About the application

Application number: 2024/91171	
What is the application for?:	Erection of single storey front and two storey rear extensions (within a Conserv
Address of the site or building:	42, Underbank Old Road, Holmfirth, HD9 1EA
Postcode:

Project:
Single Storey Front Extension and Parking Provision
at 42 Underbank Old Road,
Holmfirth,
HD9 1EA
for S. Swift
Proposed Plan, Elevations And Block Plan

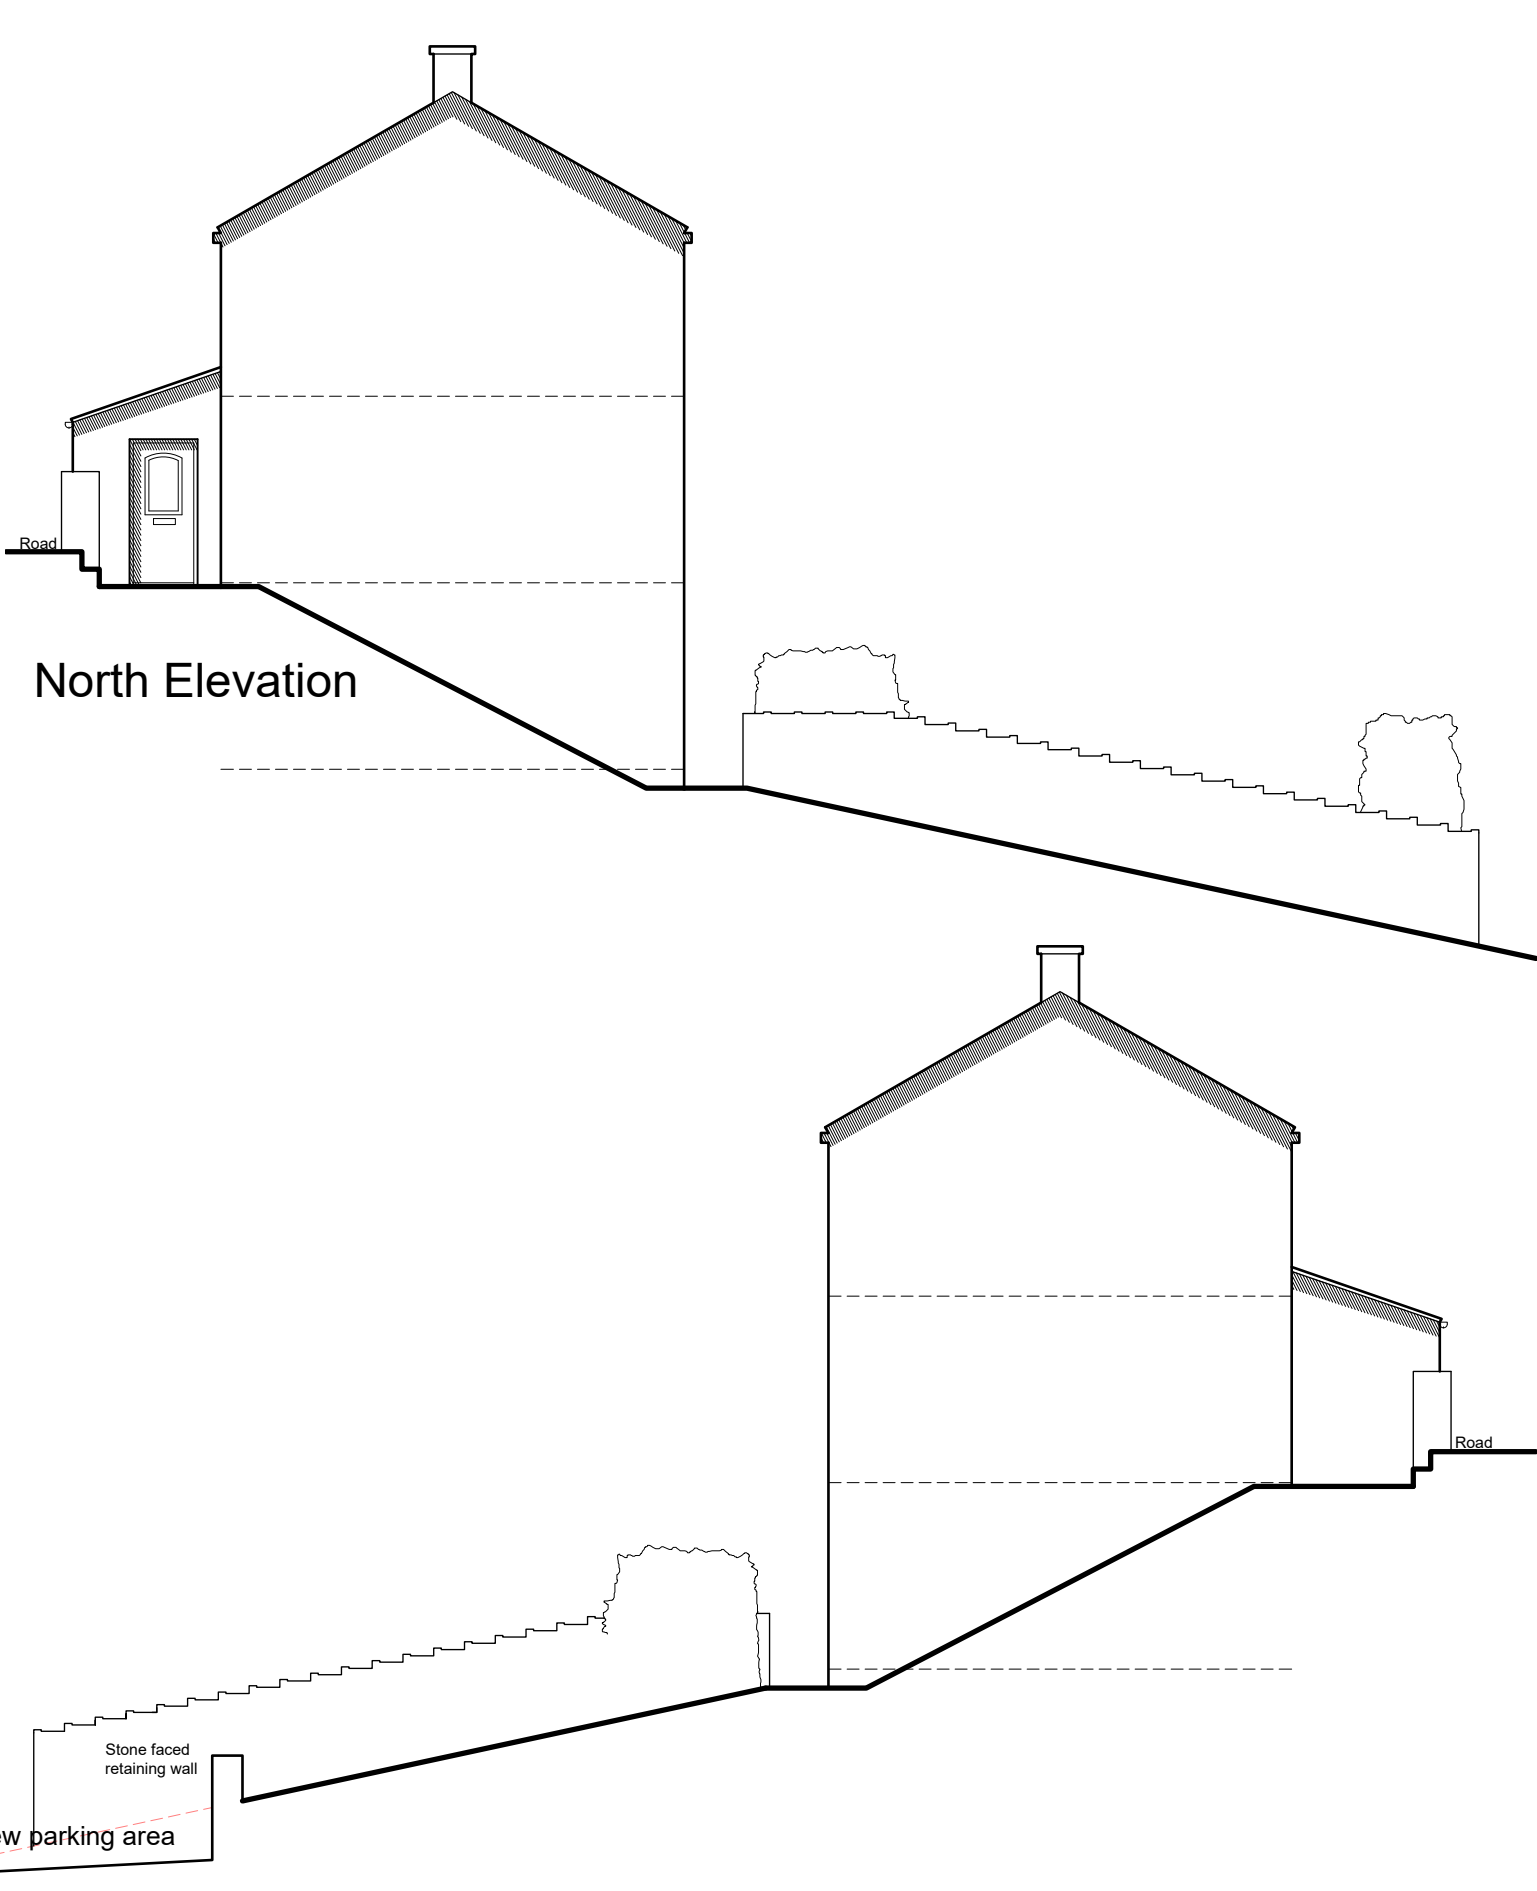
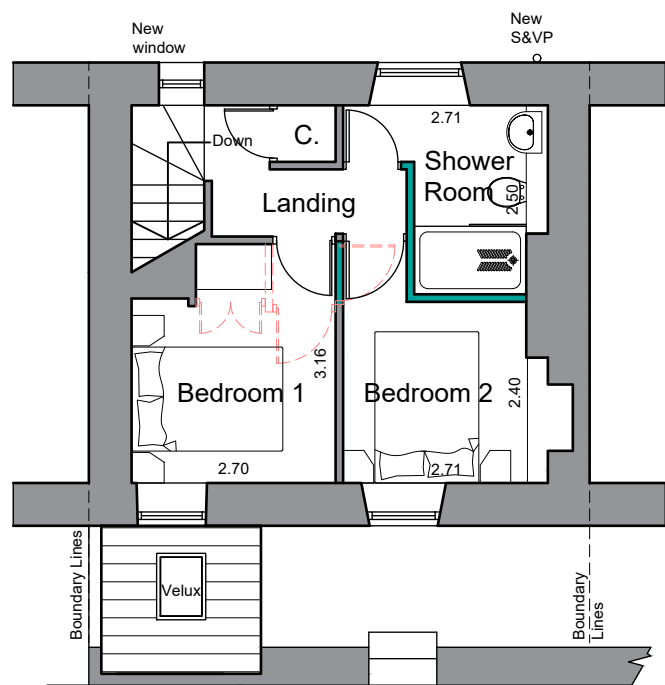
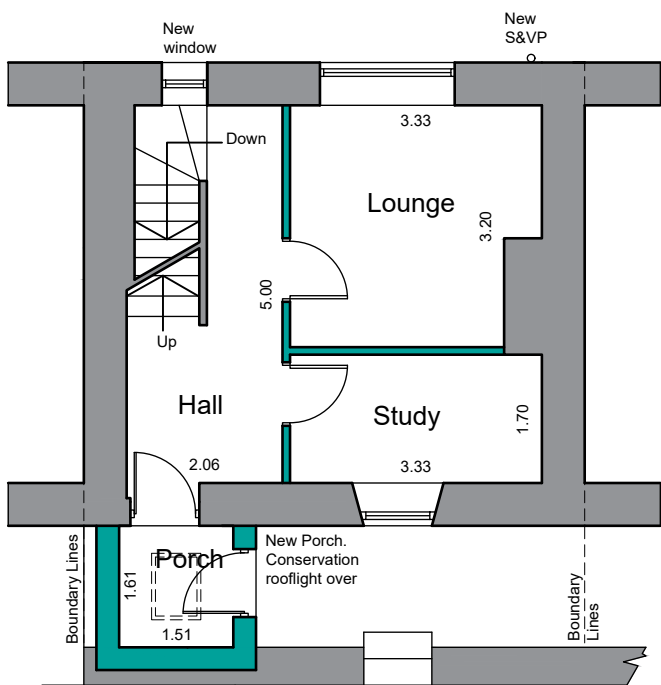
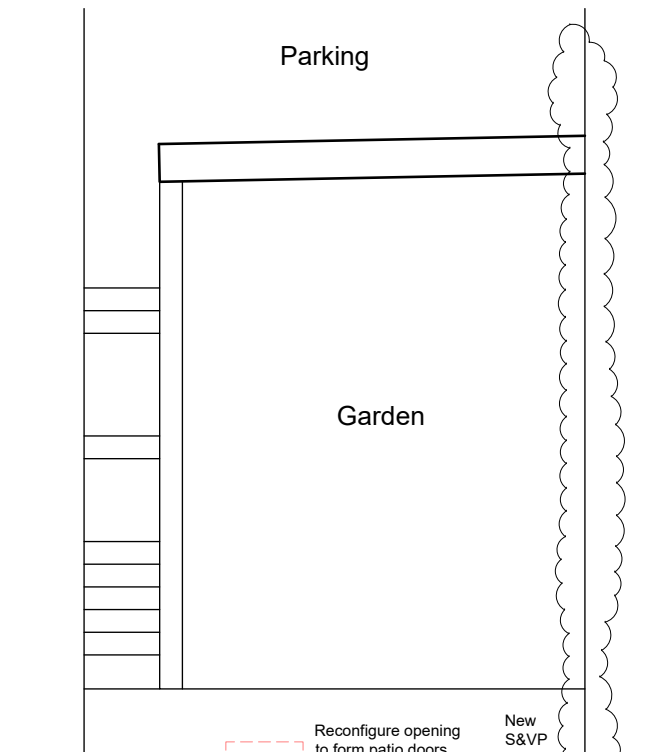
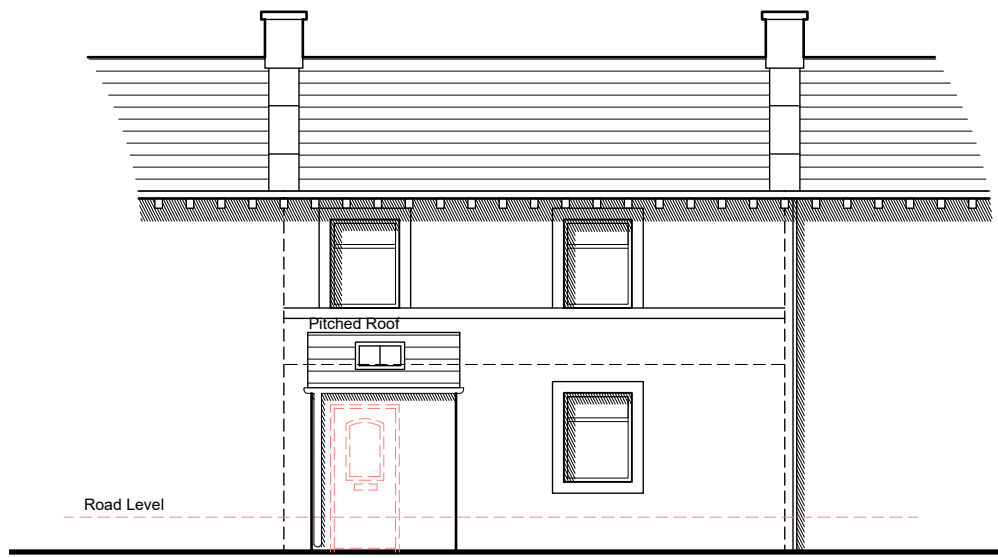
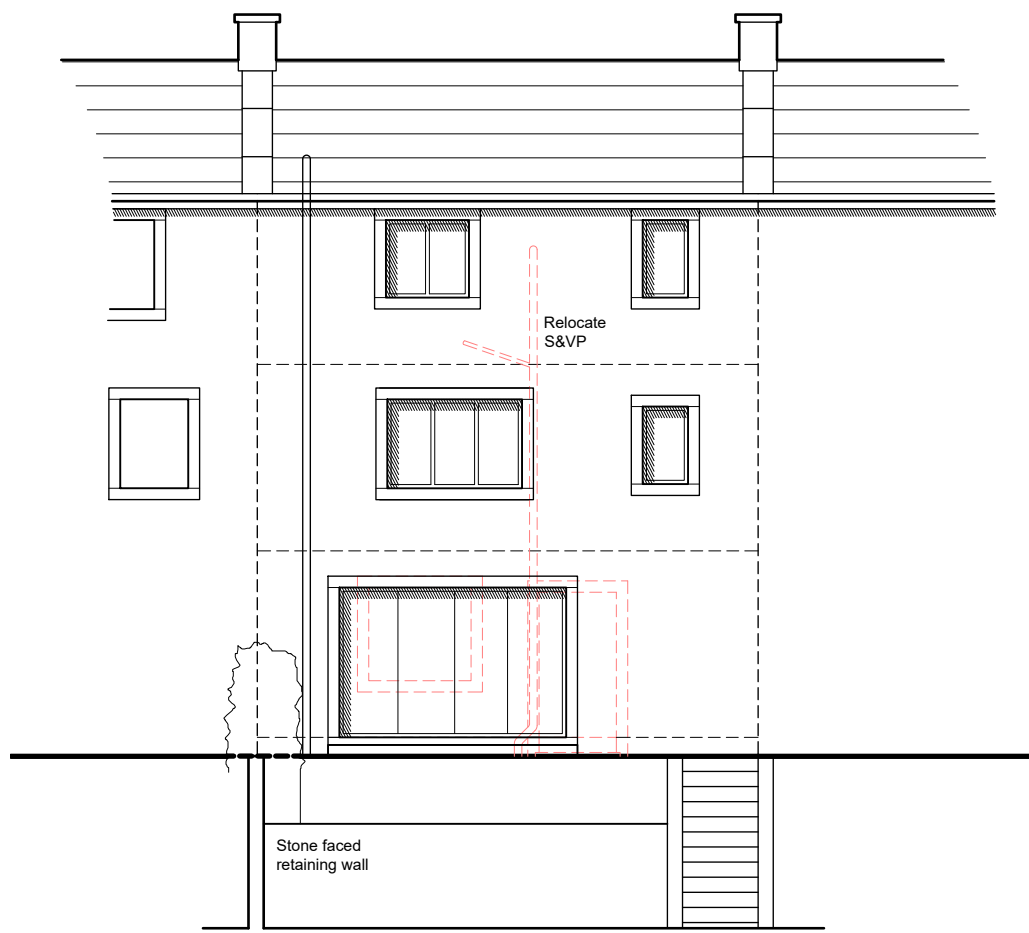
Type of comment: An objection	
Do you wish your comments to be published on the website anonymously?	Yes
I live at no 40 Underbank Old rd on the north side of the development. I have no objection to proposed porch on the front. I strongly object to the two story extension to the rear. Two points to note. The measurement shown on the west elevation of 3.3m to the eaves is in fact 4.050m, due to ground level being lower than internal floor level. The second point point being again on the west elevation the upper ground floor window is shown but the applicant has failed to include the ground floor window underneath. Which is in fact my office/study. That would mean a 3m x 4m wall 1m away from my window. At this time of year direct sun light would not reach the ground floor window until approx 5.30pm. There have been various developments in the conservation area, both single story. There is nothing of this size. It would completely change the look of Lowgate and I consider it out of keeping with in a conservation area.
